Please ask for: Ms Iqraa Malik
Email: iqraa.malik@terraquest.co.uk
Telephone: 0121 234 1390
Our Ref: FP/206/21/HH
Your Ref:
Date: 23rd September 2021

Application for Planning Permission for Works or Extension to a Dwelling

Development: Single storey front porch/garage extension
Location: 10 Old Manor House Gardens Felpham PO22 8QR

Existing Site Plan - 1:200

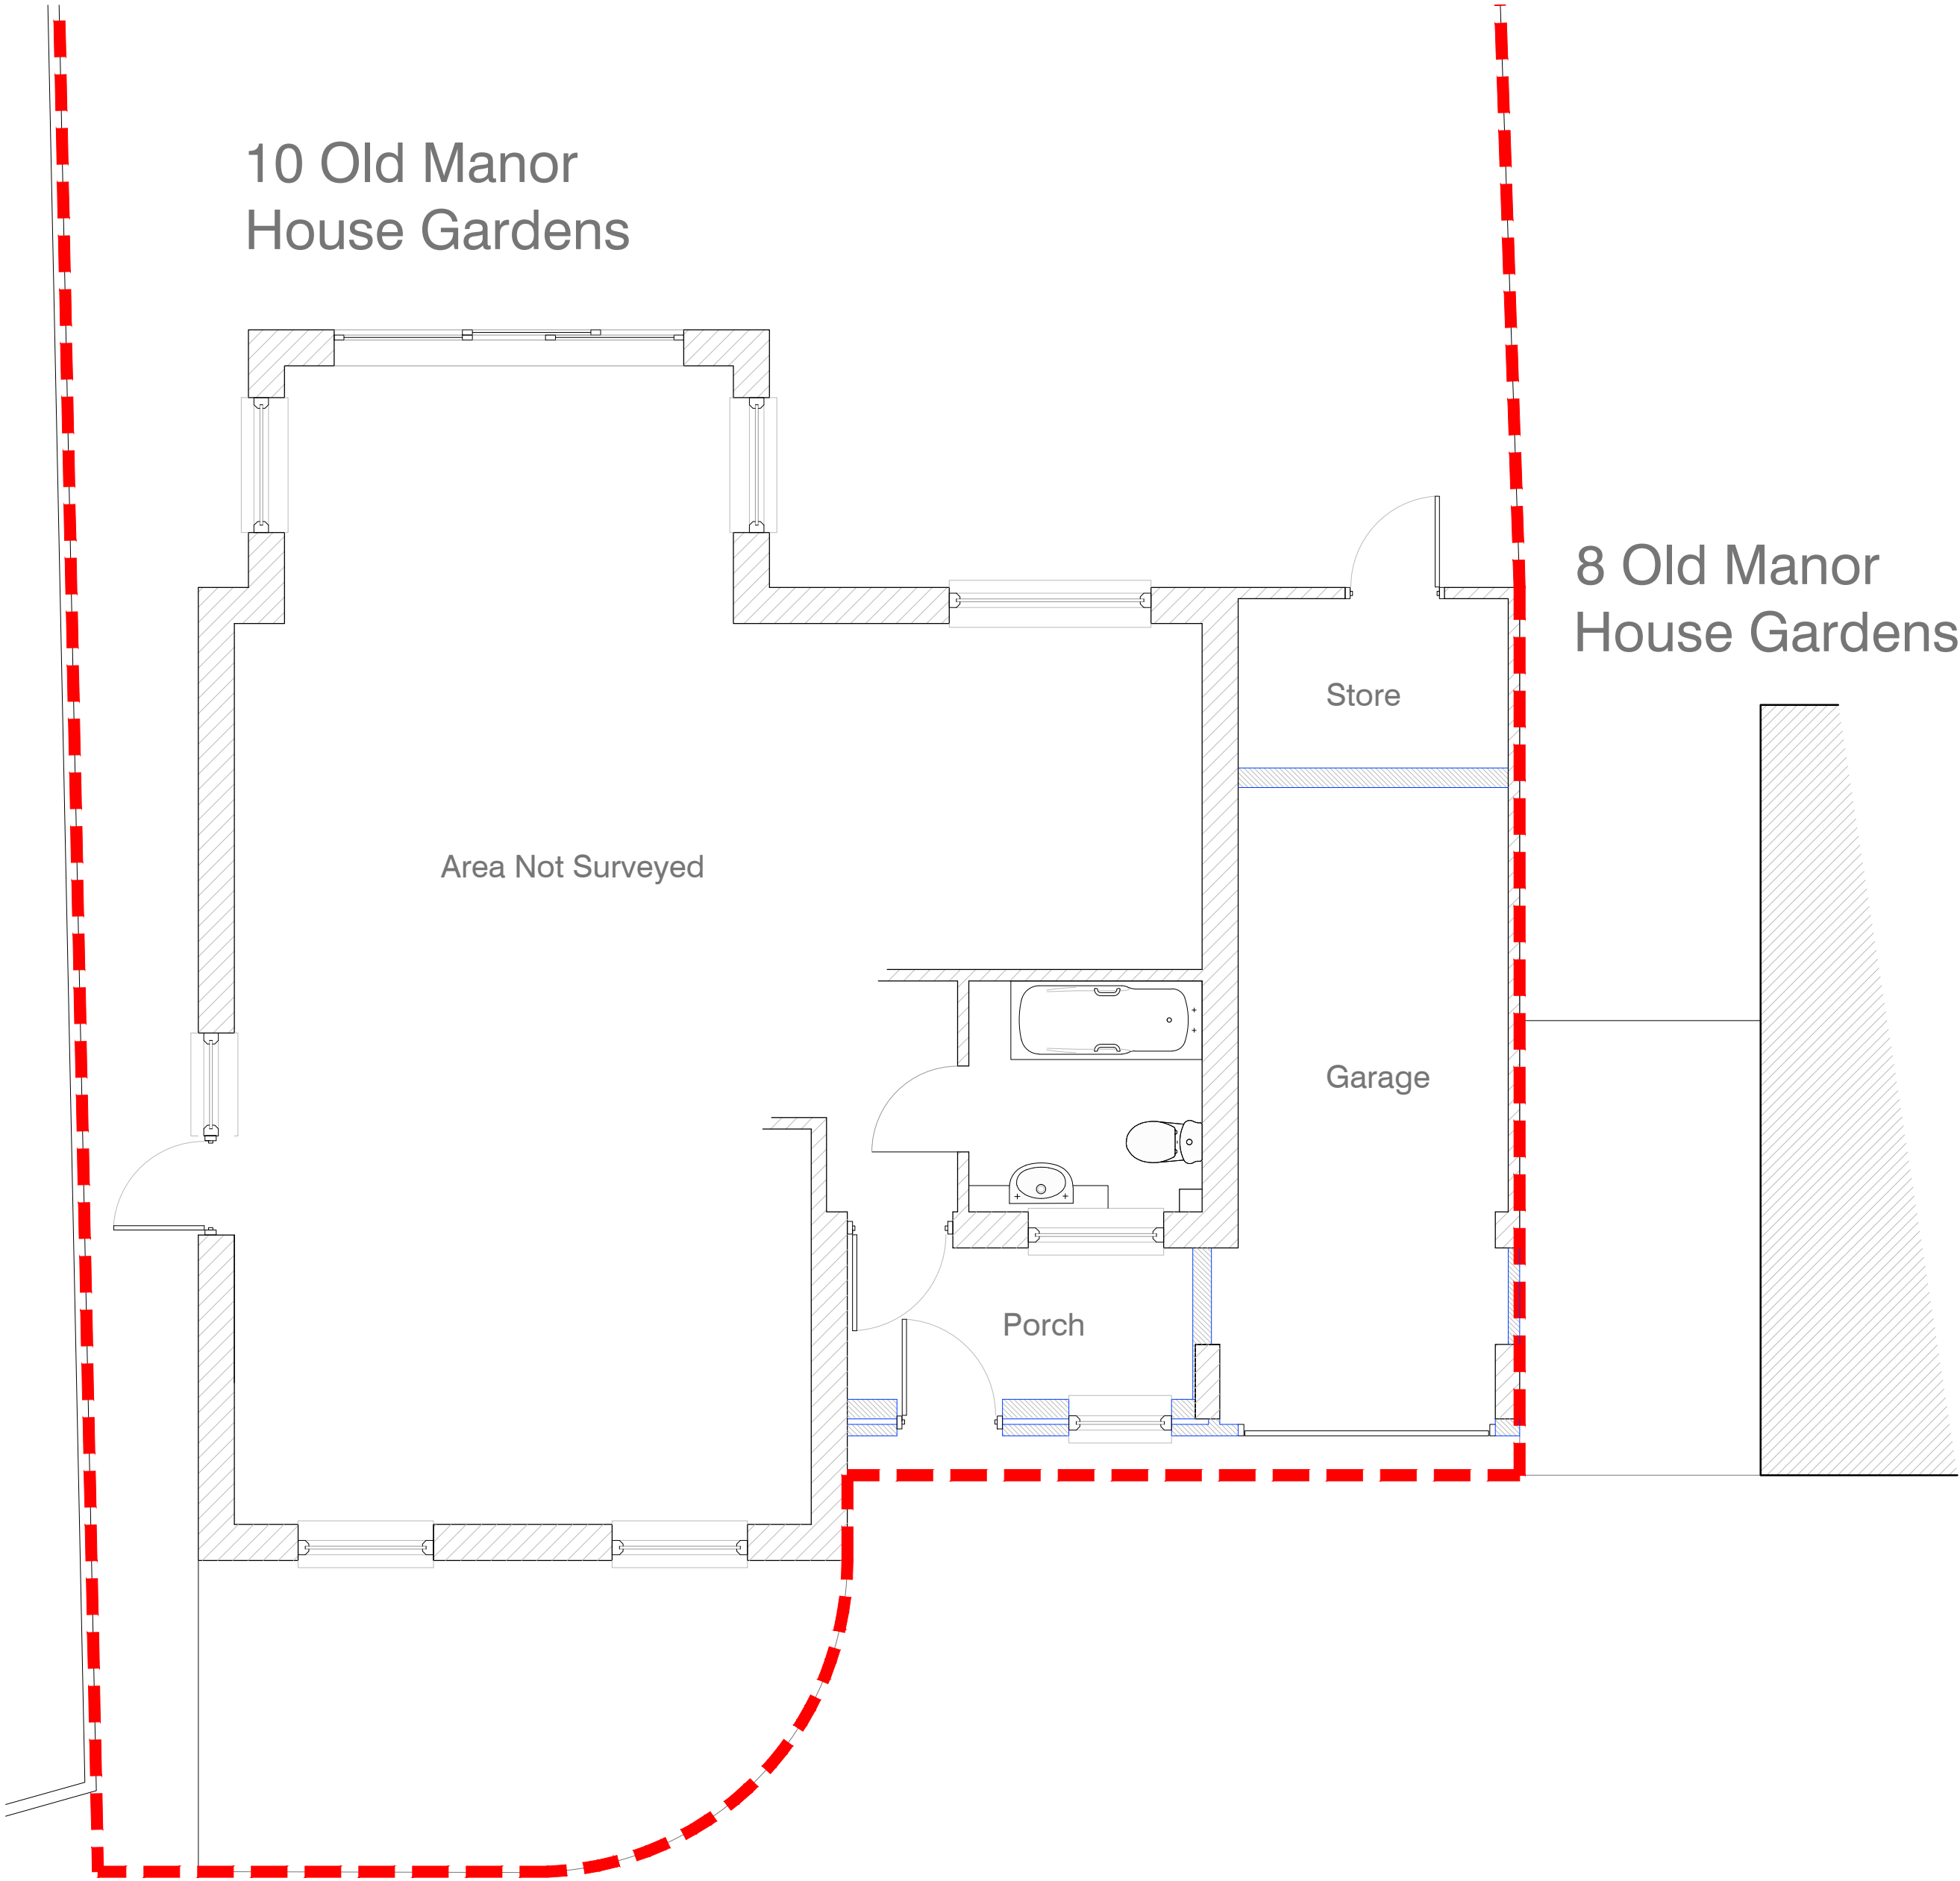
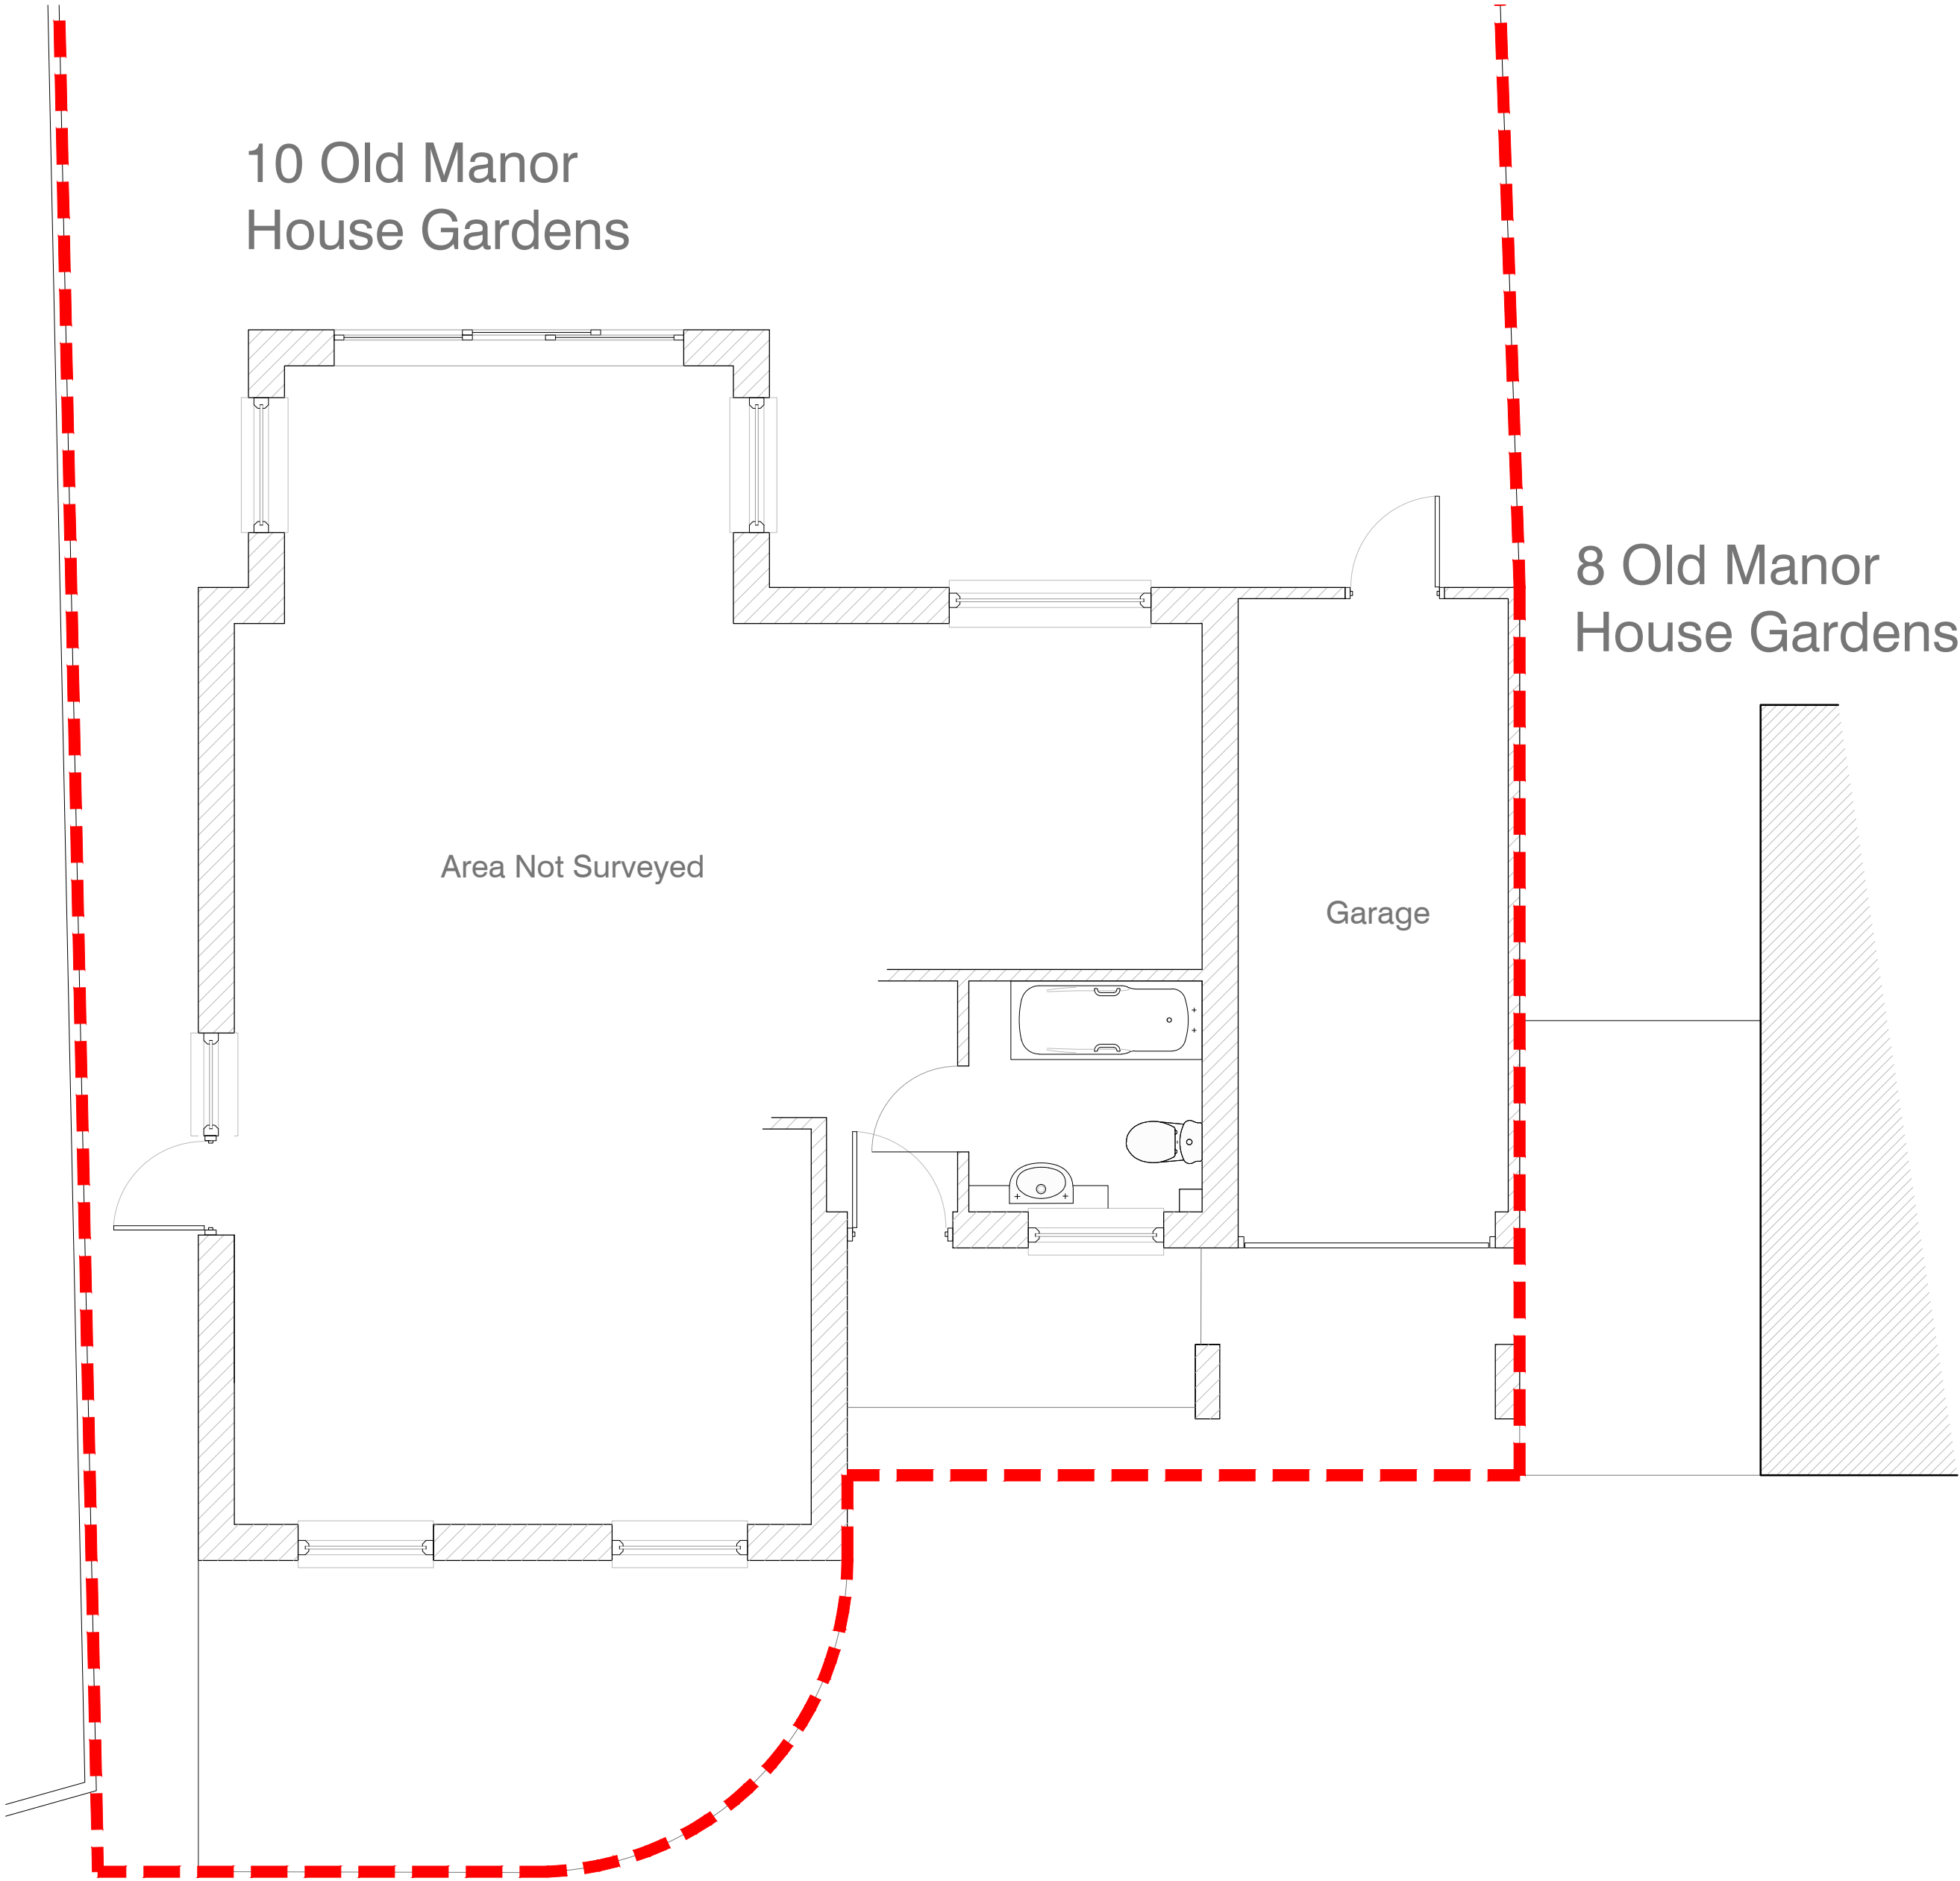
The existing and proposed site plans appear to be the same. Please review and amend.

**10 Old Manor House
Gardens, Bognor Regis**

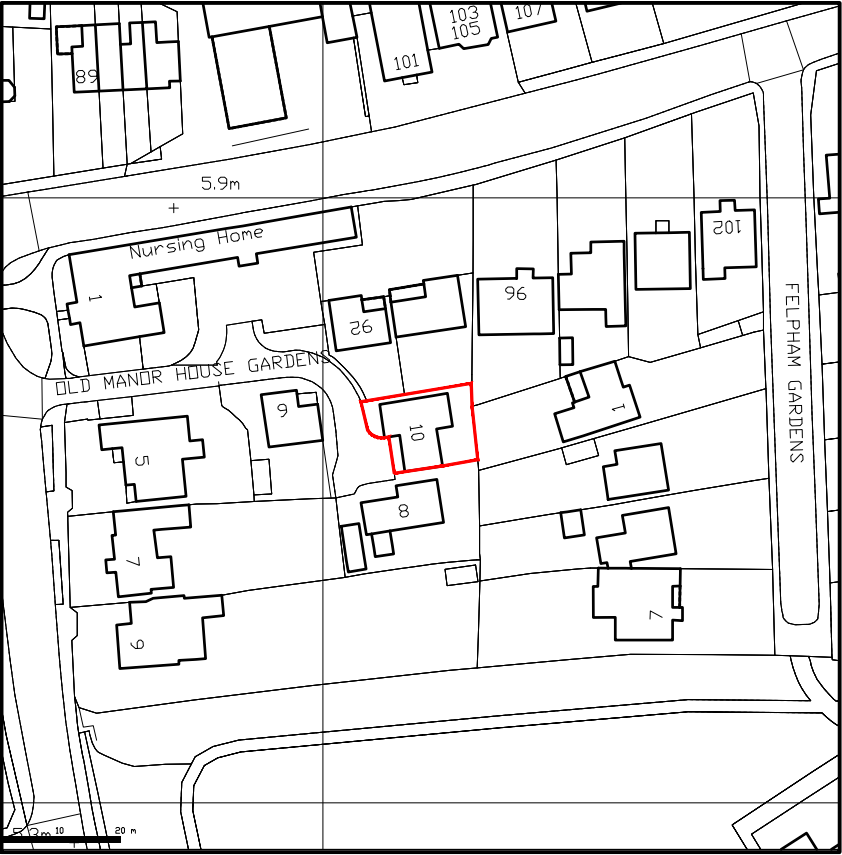
The location plan requires a solid red outline around the site boundary. Please amend. Further details of what must be included on the plan can be found in the Validation Requirements List.

Title
Proposed Dimensions from
Boundary

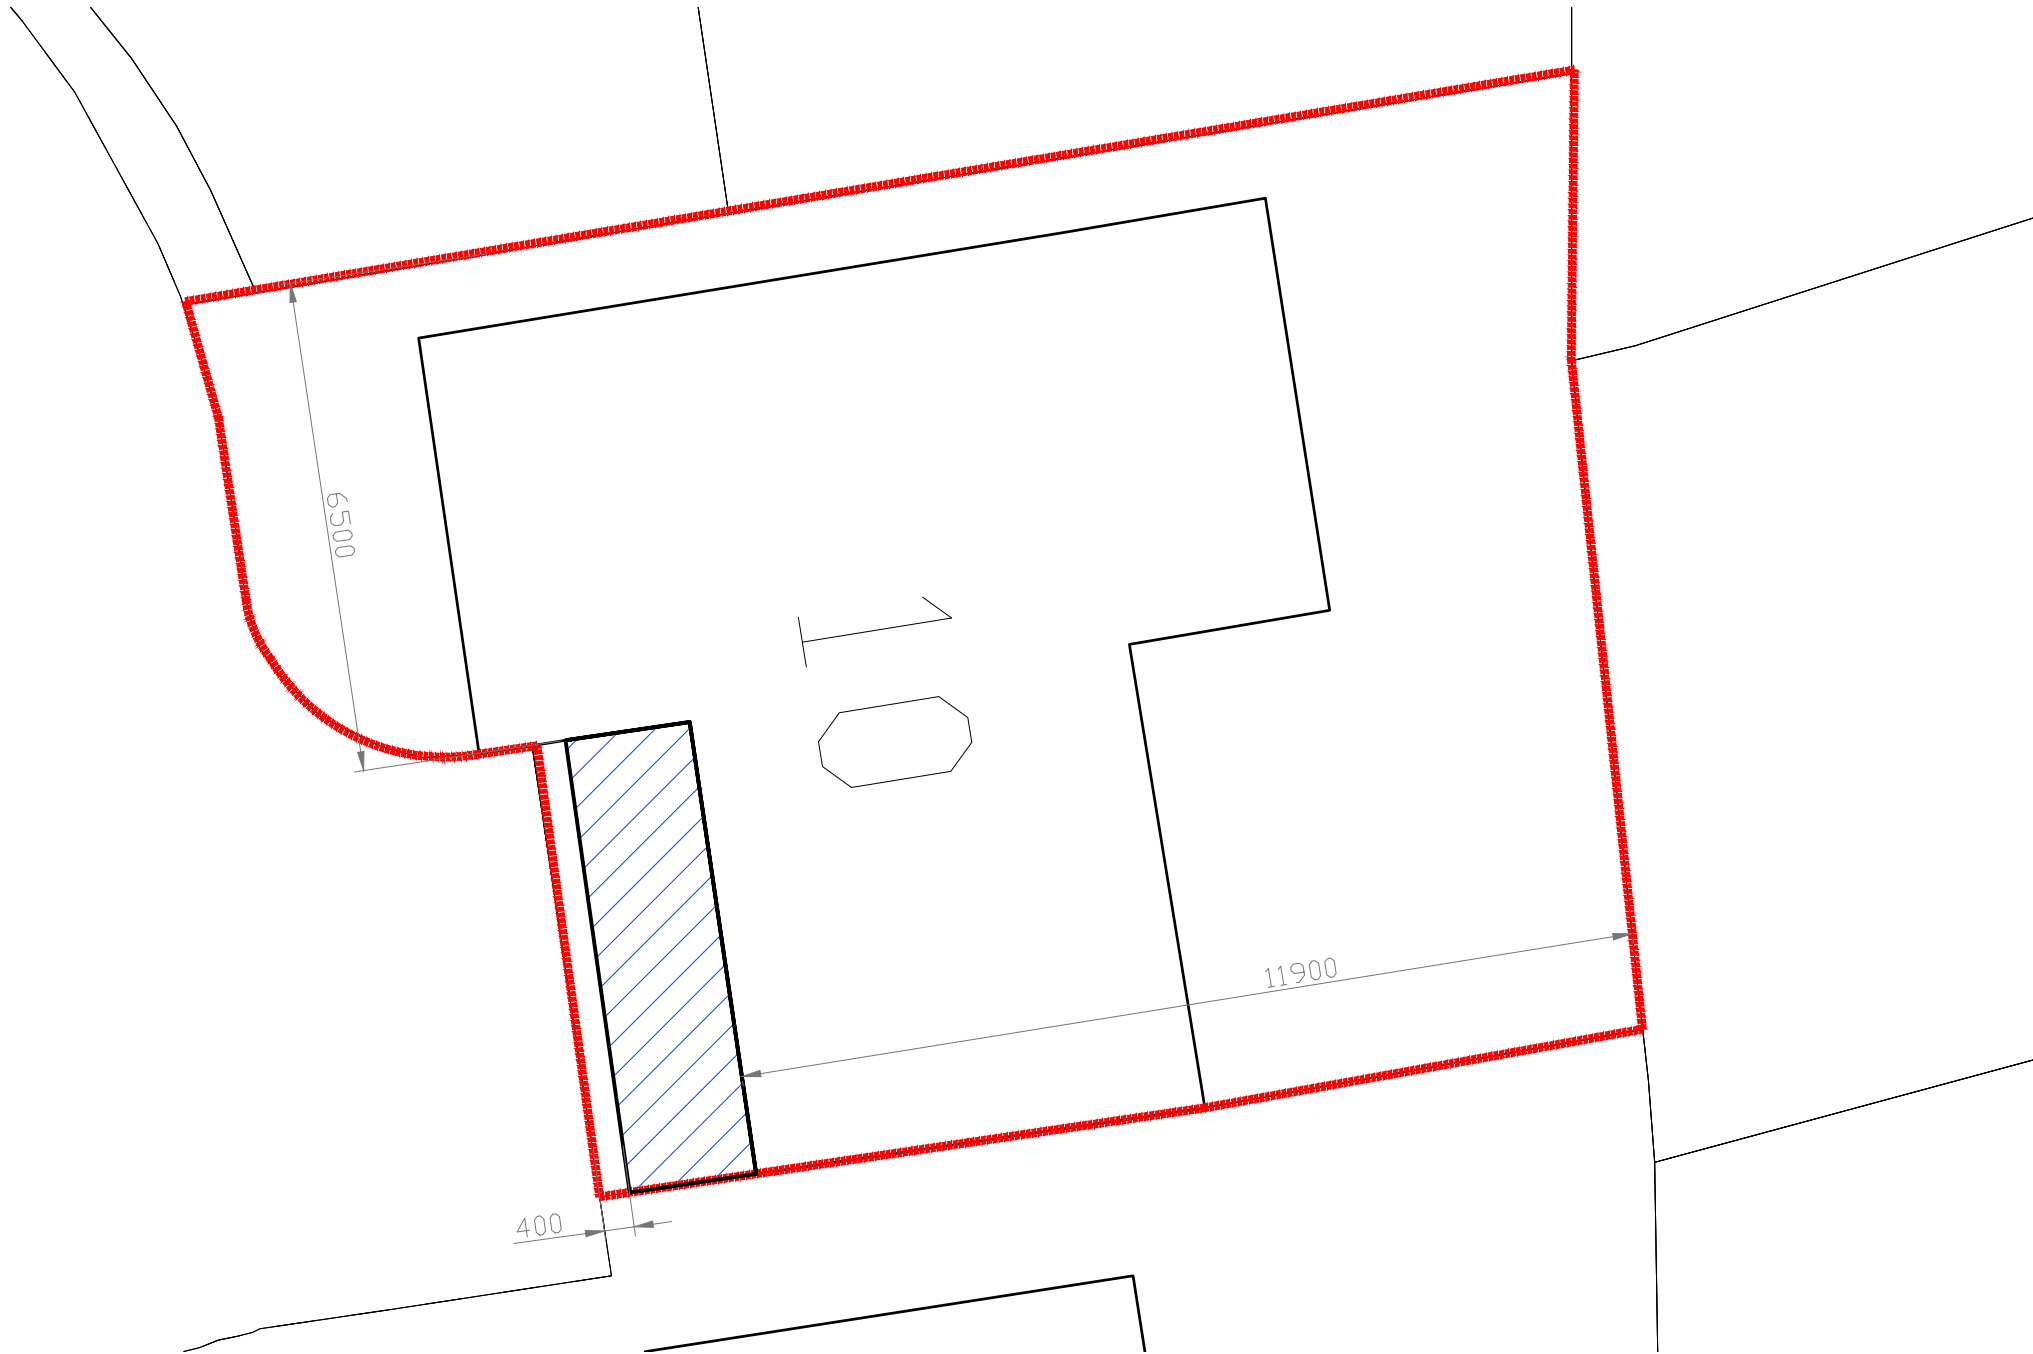
You are required to have dimensions from the proposed extension(s) to all site boundaries. Please amend.
